TfL Post Stage 1 Comments:

Broadwater Lake

Stage 1 Comment: (11 th Dec 2023)	Revised scheme comment: (11 th March 2026)
Access	
Access to the site is via a private access road off Moorhall Road. There are currently no footways or street lighting present on the access road. Improvements to this site access road and junction, which includes the provision of a dedicated pedestrian footway, new street lighting and introduction of a 20mph speed limit are proposed. These improvements have been subject to a Stage 1 Road Safety Audit, the findings of which should be considered with the relevant highway authority.	As the highway authority the RSA should be agreed by Hillingdon. Access improvements have been highlighted including new street lighting. Confirmation of where this is to be located and how this is to be secured is required.
It should be ensured that the proposed access is designed in line with the Mayor's Healthy Streets approach, with priority given to modes of sustainable and active travel over that of private vehicle. On the General Arrangement Plans there are several stretches of access road where the footpath changes sides without any crossing or demarcation. This should b

Figure 3.6: Site wide parking arrangements

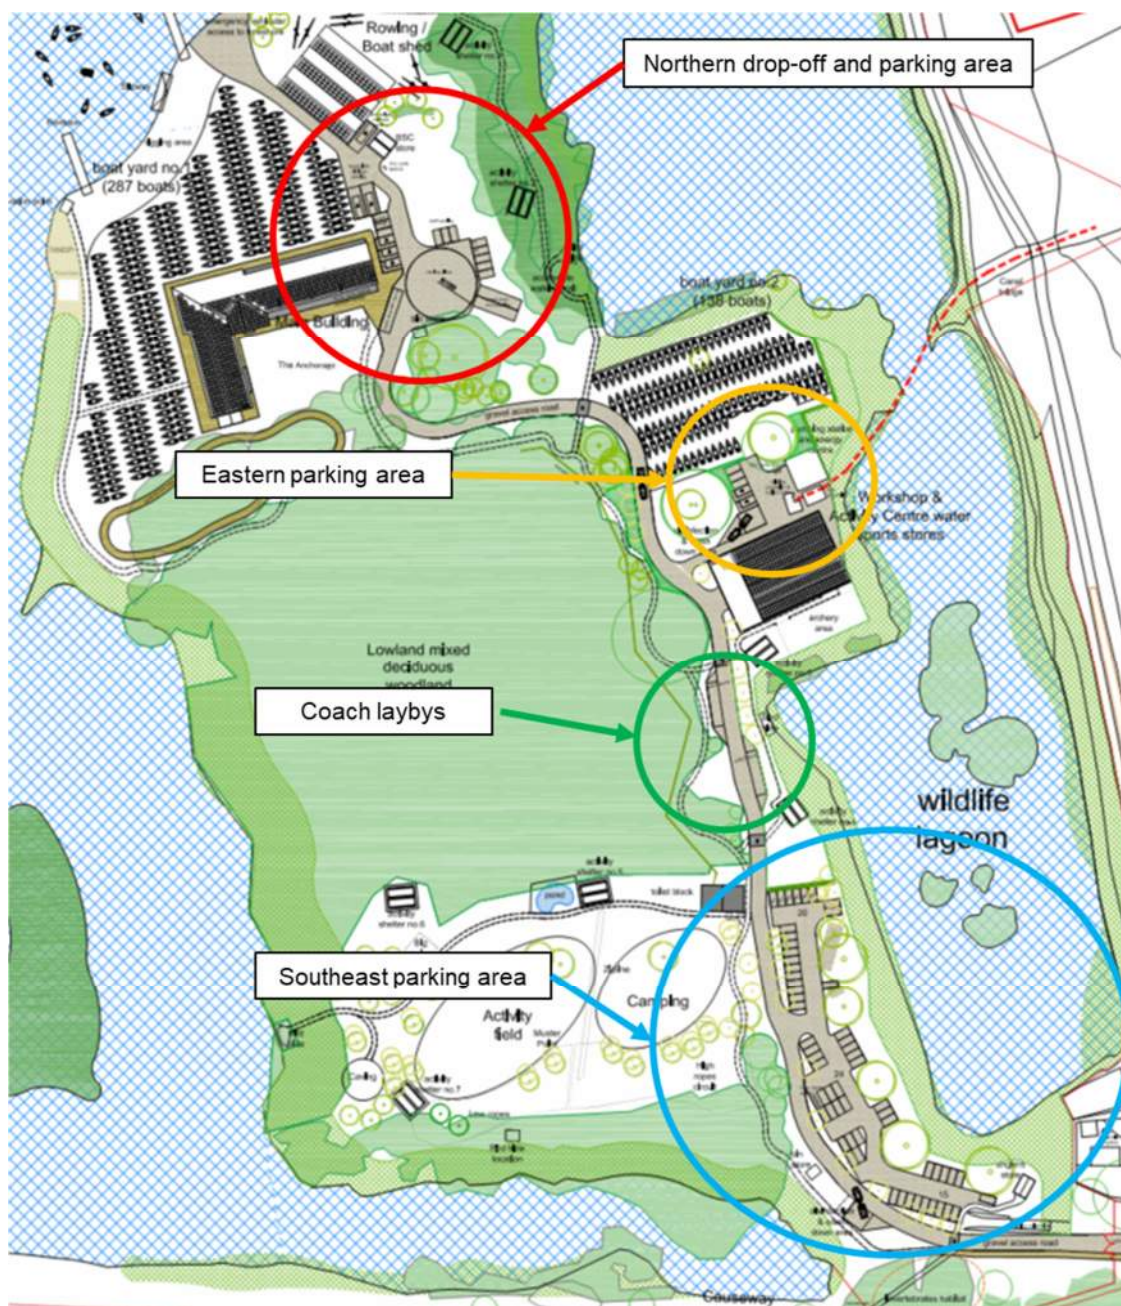
pedestrians. Additionally, the proposed footpath and pedestrian crossings need to be shown more clearly on the swept path analysis. Further information on signage and wayfinding, within the site and on adjoining streets and the canal are required to be delivered.	
Car Parking	
A total of 83 vehicle parking spaces are proposed across the site. As noted in Policy T6.4, parking for leisure uses should be assessed on a 'case-by case basis, ensuring that it is consistent with the Healthy Streets Approach, mode share and active travel targets, and the aim to improve public transport reliability and reduce congestion and traffic levels.' No clarity has been provided on how the figure of 83 was arrived at. Furthermore, when noting the information on number of peak users over a day, there is a concern that 83 parking spaces is a significant overprovision	<i>'A total of 42 vehicular parking spaces are provided'</i> , plus drop off facilities. This represents a reduction of 41 spaces from the previous scheme, which TfL welcomes. However, further information on how the car parking figure has been arrived at is required in order to ensure the proposals meet all relevant London Plan policy and robustly demonstrates case by case parking policy. TfL also query the ability for informal parking on the access roads. Appropriate design and management measures should be implemented to ensure there is no overspill parking.

Whilst the isolated nature of the proposed development is noted, in line with the Mayor's strategic mode shift target, it is considered that additional measures could be implemented to support instilling sustainable and active travel to this site. Noting the aforementioned, a reduction in the quantum of car parking is sought	As above.
The disabled persons car parking spaces should accord with the requirements of London Plan policy T6.5 in number and design. Further information on the infrastructure to facilitate safe, equal for all and comfortable drop-off's and pick-ups at the coach bays is required. Sited alongside the access road, appropriate shelters, pedestrian routes and waiting areas need to be indicated. All operational parking must provide facilities for electric charging vehicles. A Parking Development Management Plan should be secured by an appropriate mechanism to control how parking, drop-off and collection will be safeguarded for the respective users.	<i>A total of six blue badge parking bays are proposed. A total of six active EVCP are provided within the southern parking area of the site.</i> These should be secured appropriately.

Appendix D – Access design general arrangement and swept path analysis

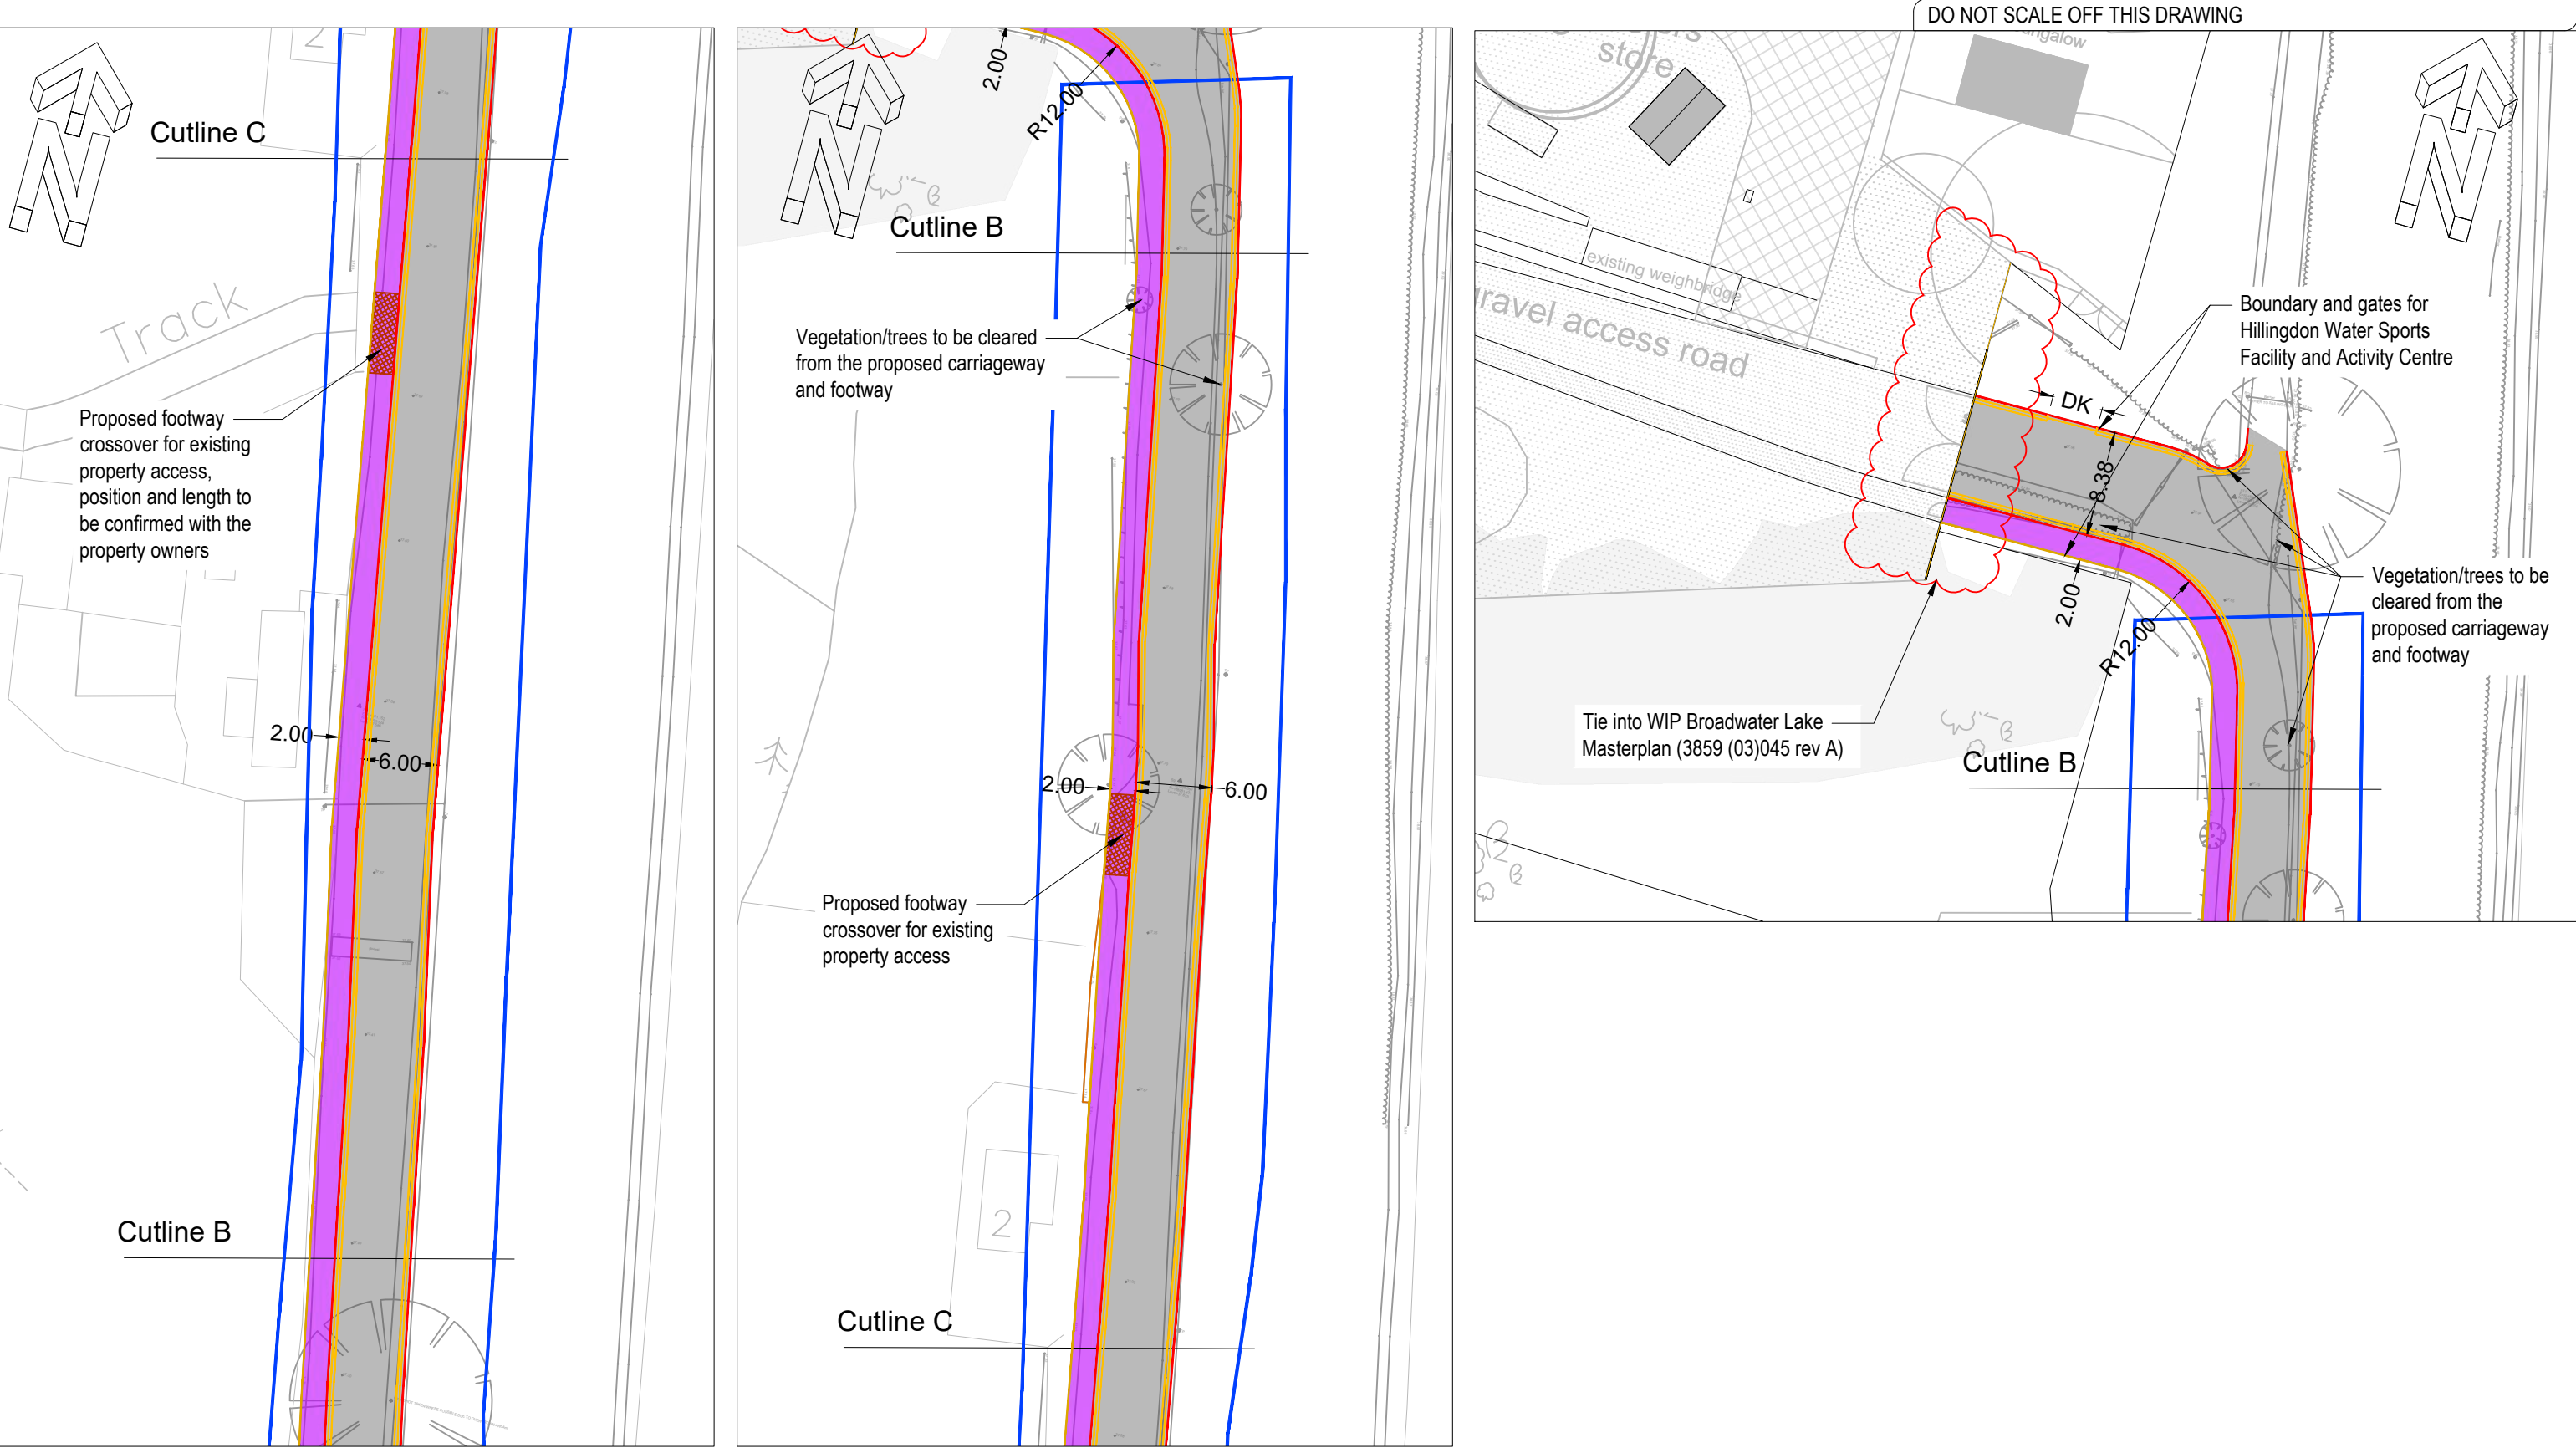
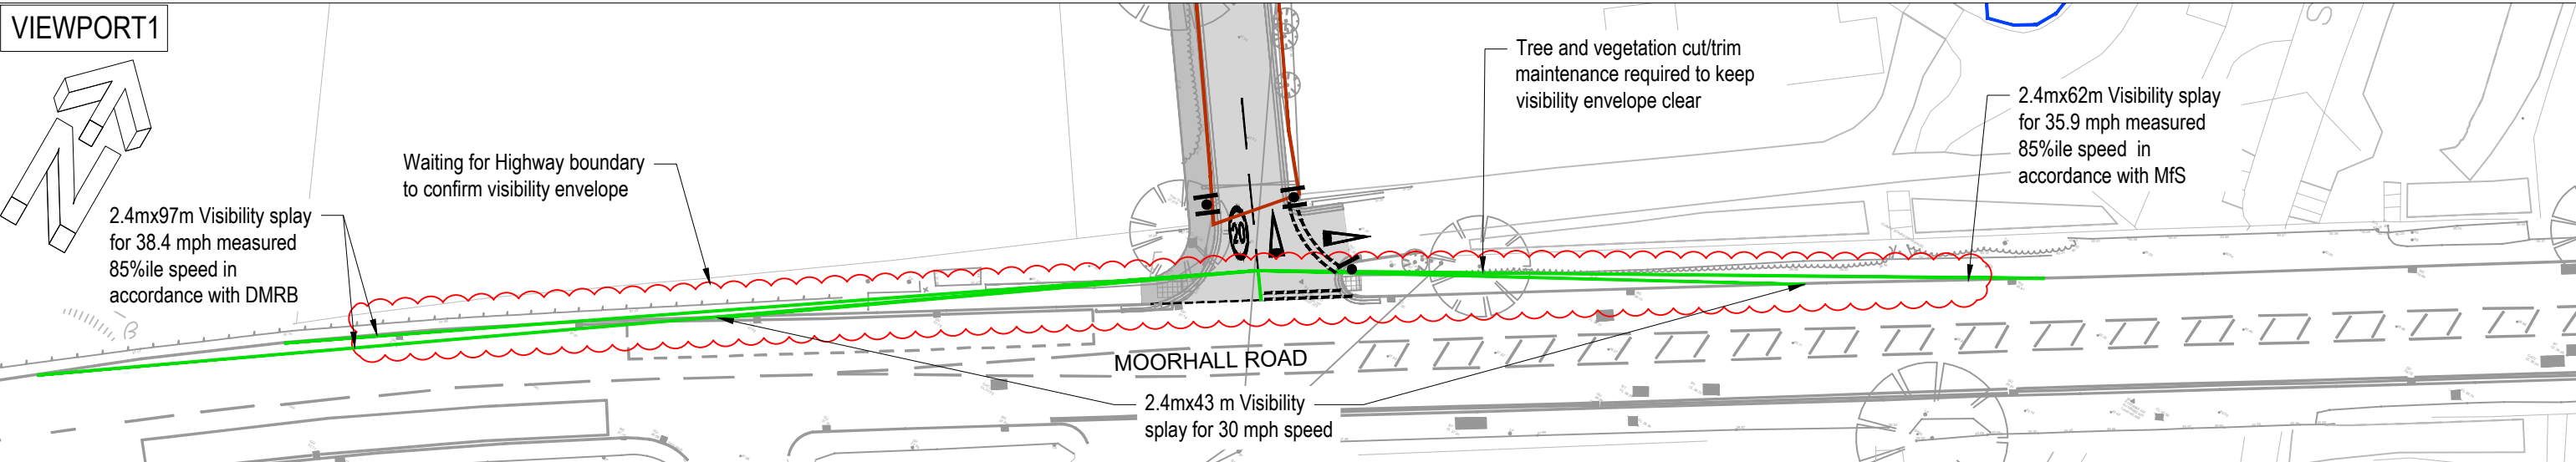
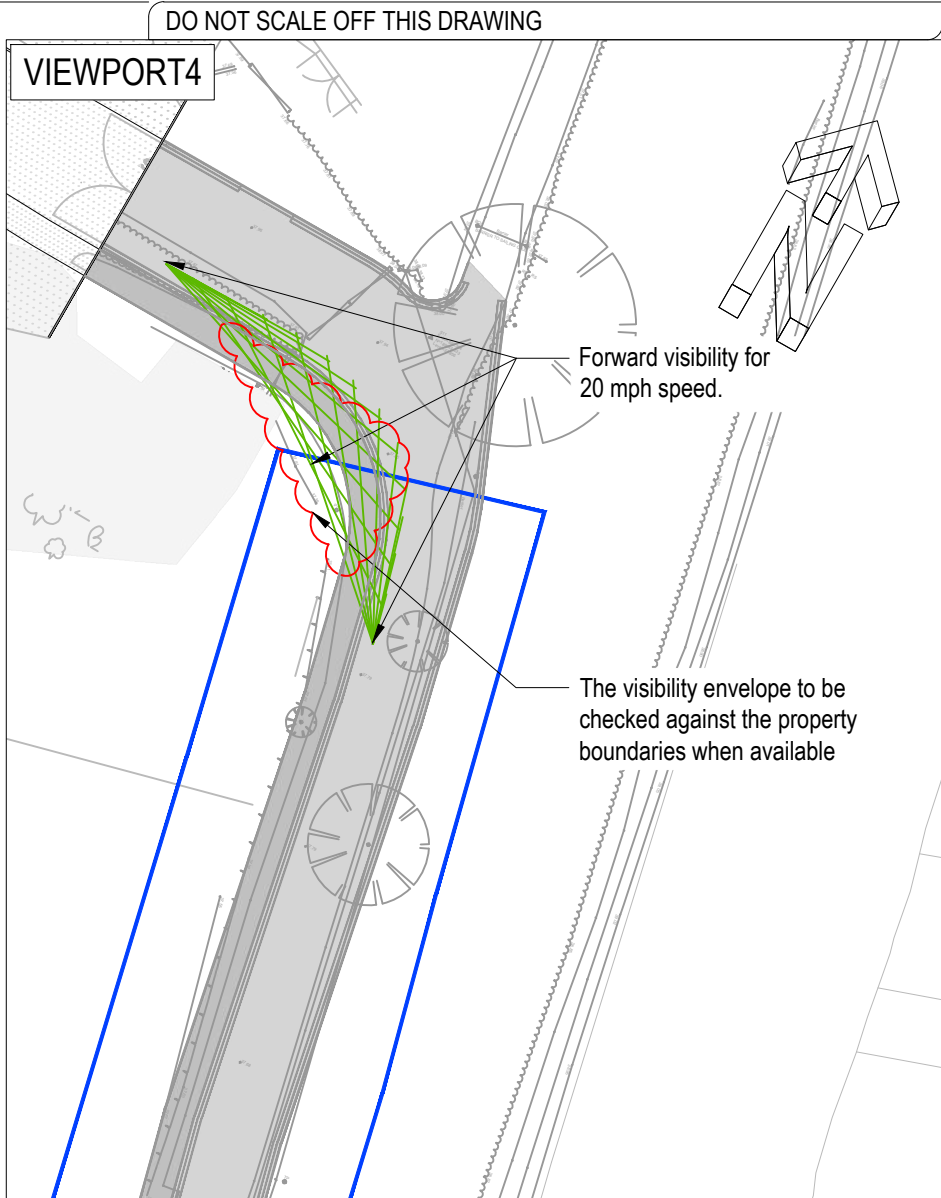
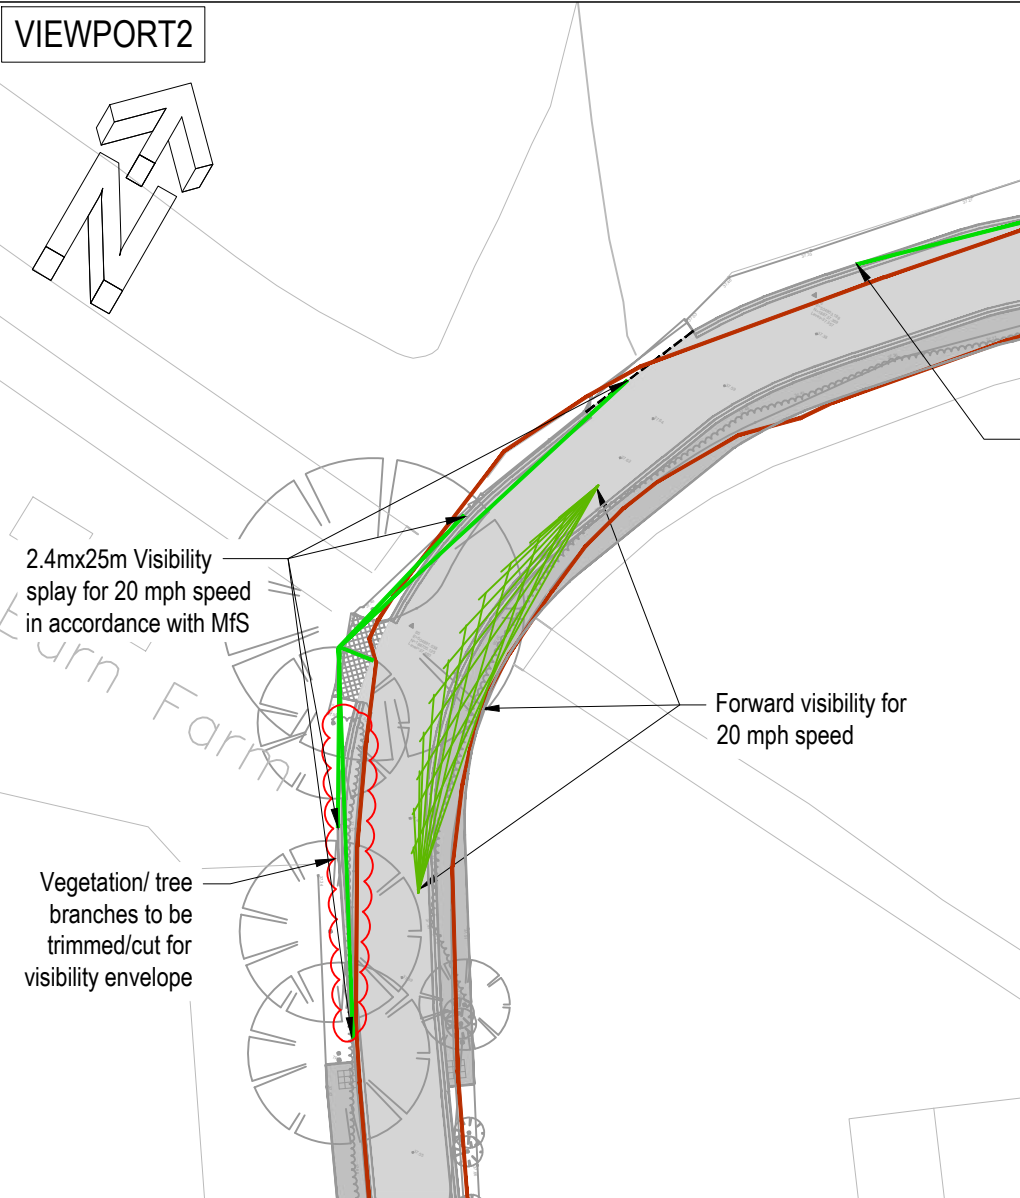
Further information is required regarding how the access road and footpath would comply with the Mayor's Vision Zero approach. As stated above, on the General Arrangement Plans there are several stretches of access road where the footpath changes sides without any crossing or demarcation. Given the curved nature of the access road this could result in poorly sighted crossing by pedestrians which could endanger the safety of pedestrians and motorists. Additionally, the footpath terminates into the car park at the end where vehicles would potentially conflict with	Clarity on the lighting strategy for the access road and the site itself is required to ensure safety and perceptions of safety with concerns around the car park. Further clarity on wayfinding is still required.
